**From:** Longridge Town Council <clerk@longridge-tc.gov.uk>  
**Sent:** 25 January 2018 20:22  
**To:** planning  
**Cc:** 'Longridge Town Council'  
**Subject:** PLANNING APPLICAITON COMMENTS

Planning Application No: 3/2017/1189 two storey extension to the side at 21 Humber Street, Longridge PR3 3WD

Client		
MR AND MRS BERRINGTON		
Job Title		
PROPOSED ALTERATIONS TO 21 HUMBER STREET LONGRIDGE		
320171189P		
Drawing Title		
PROPOSED PLANS AND ELEVATIONS		
Scale	Date	Drawn
1:100 1:50	SEPT 17	LKR
817 - 2

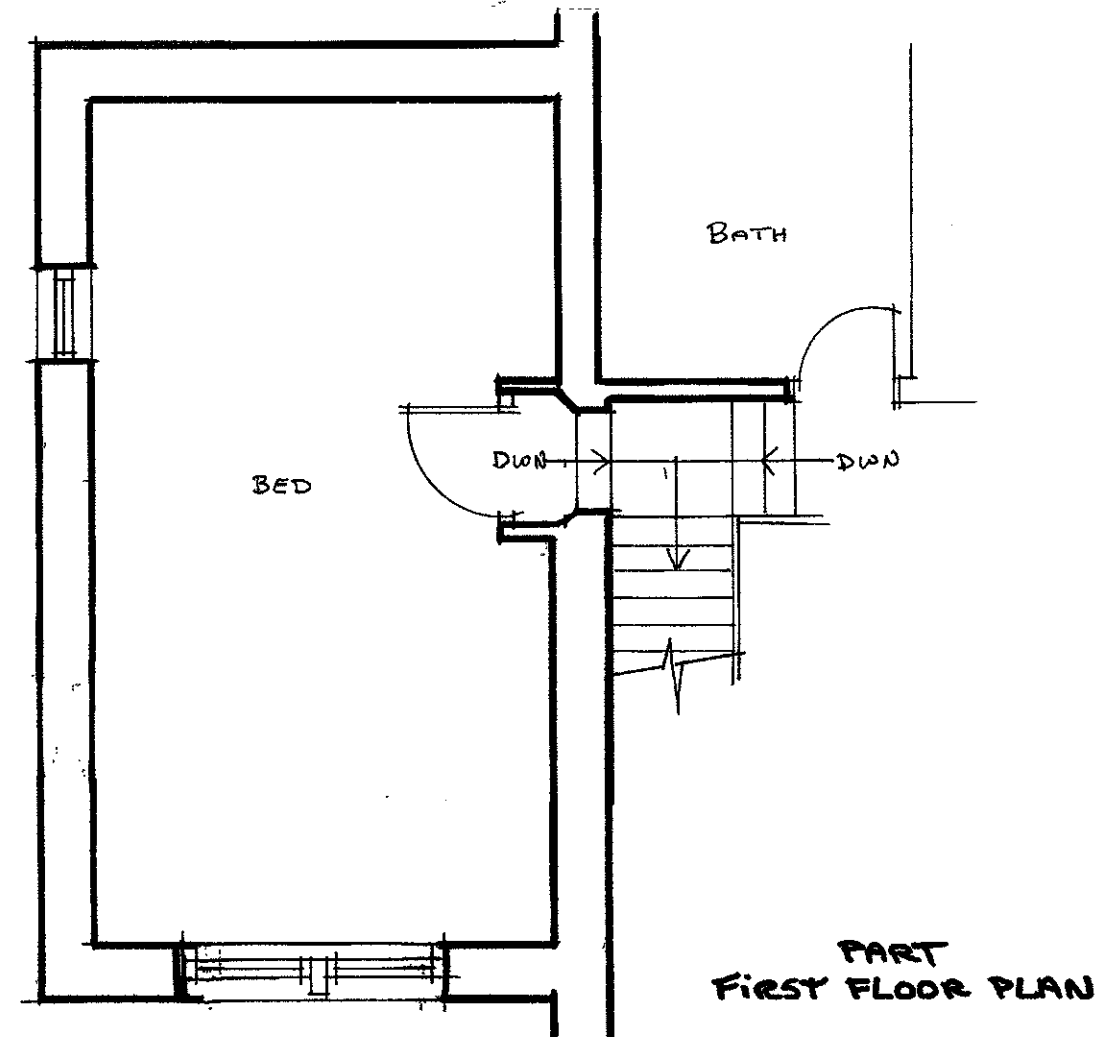
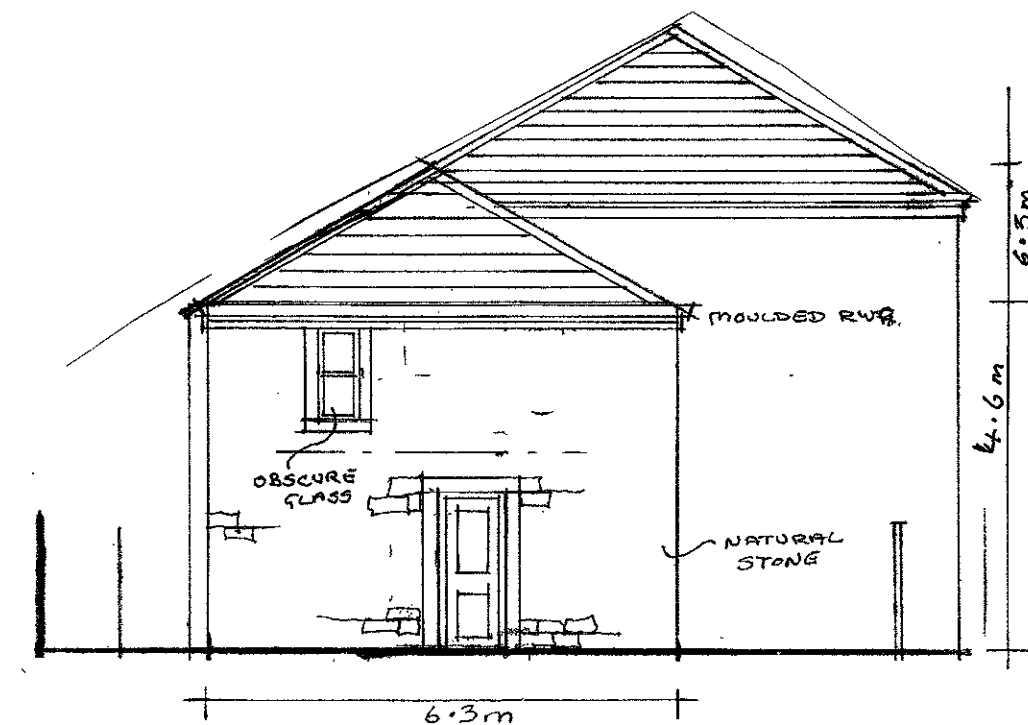
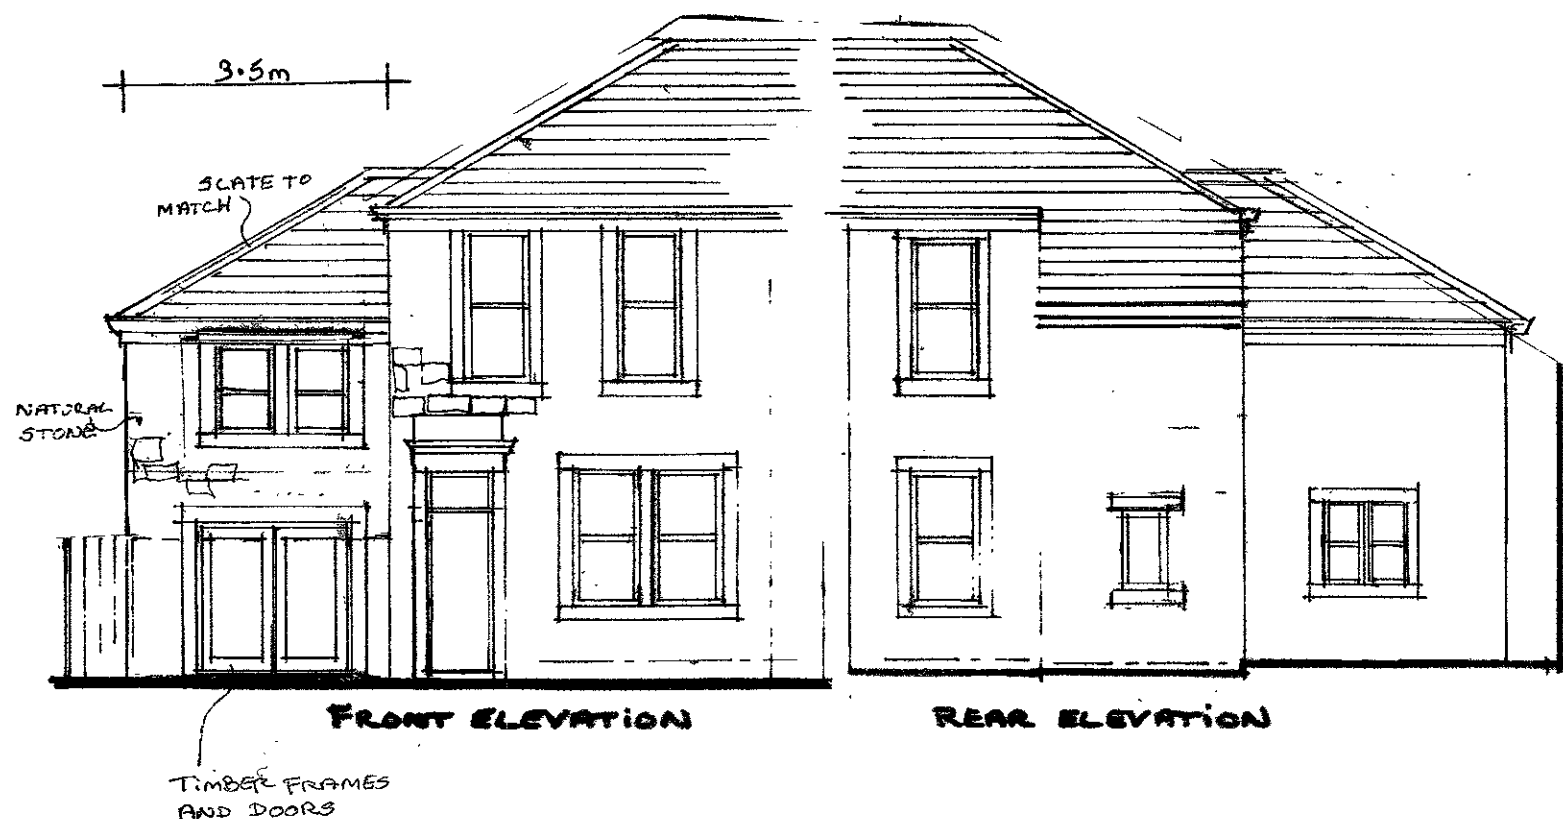
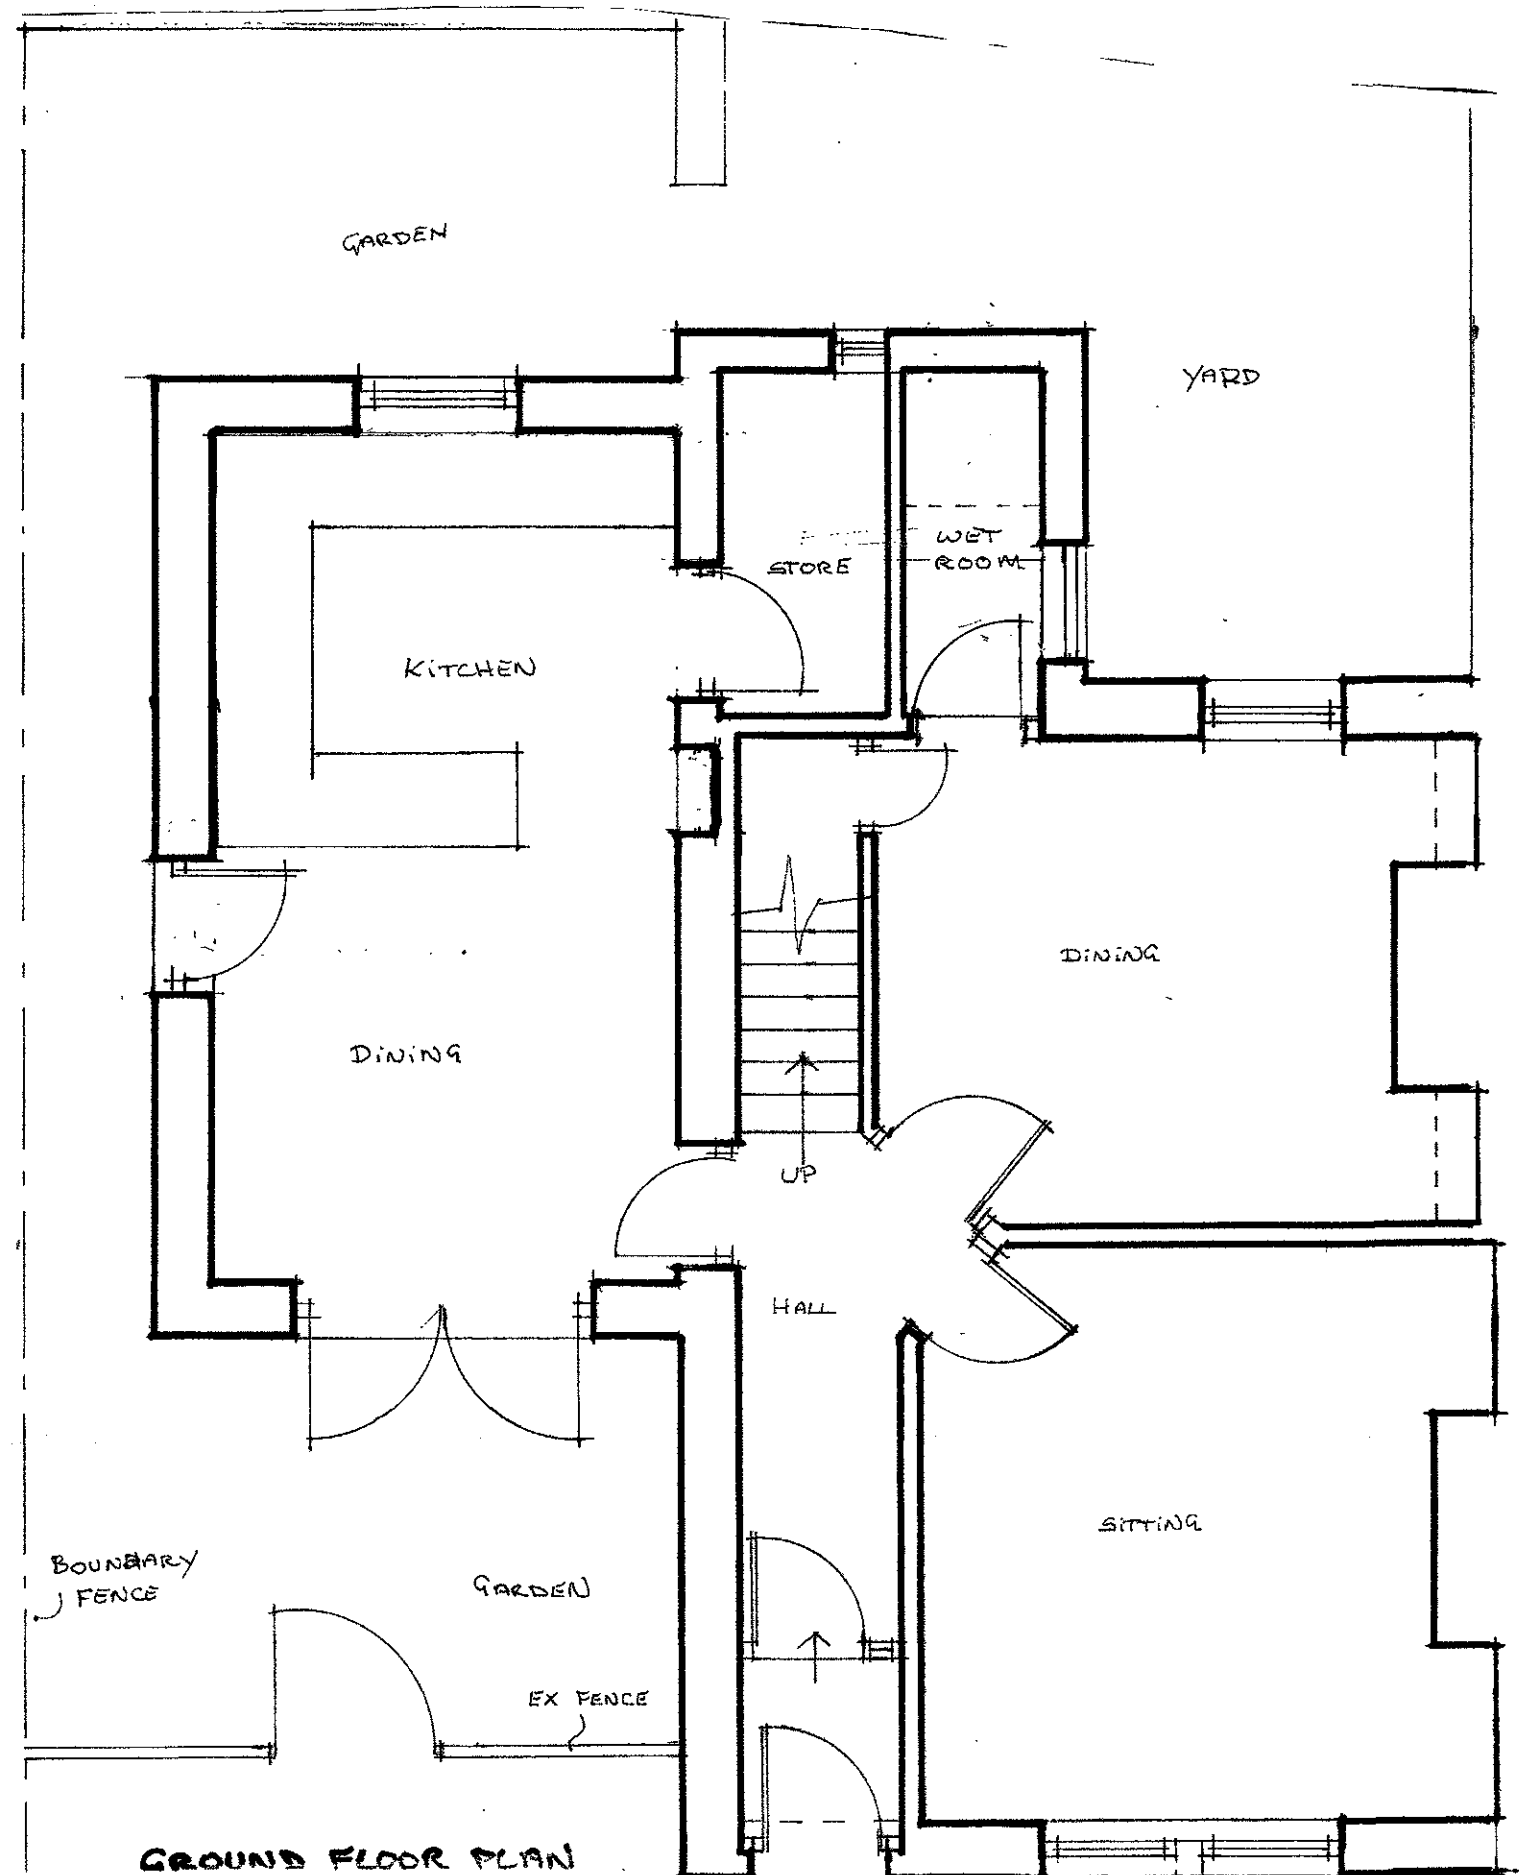
LTC - No Objection, but matching stone / materials to be used as in a conservation area.
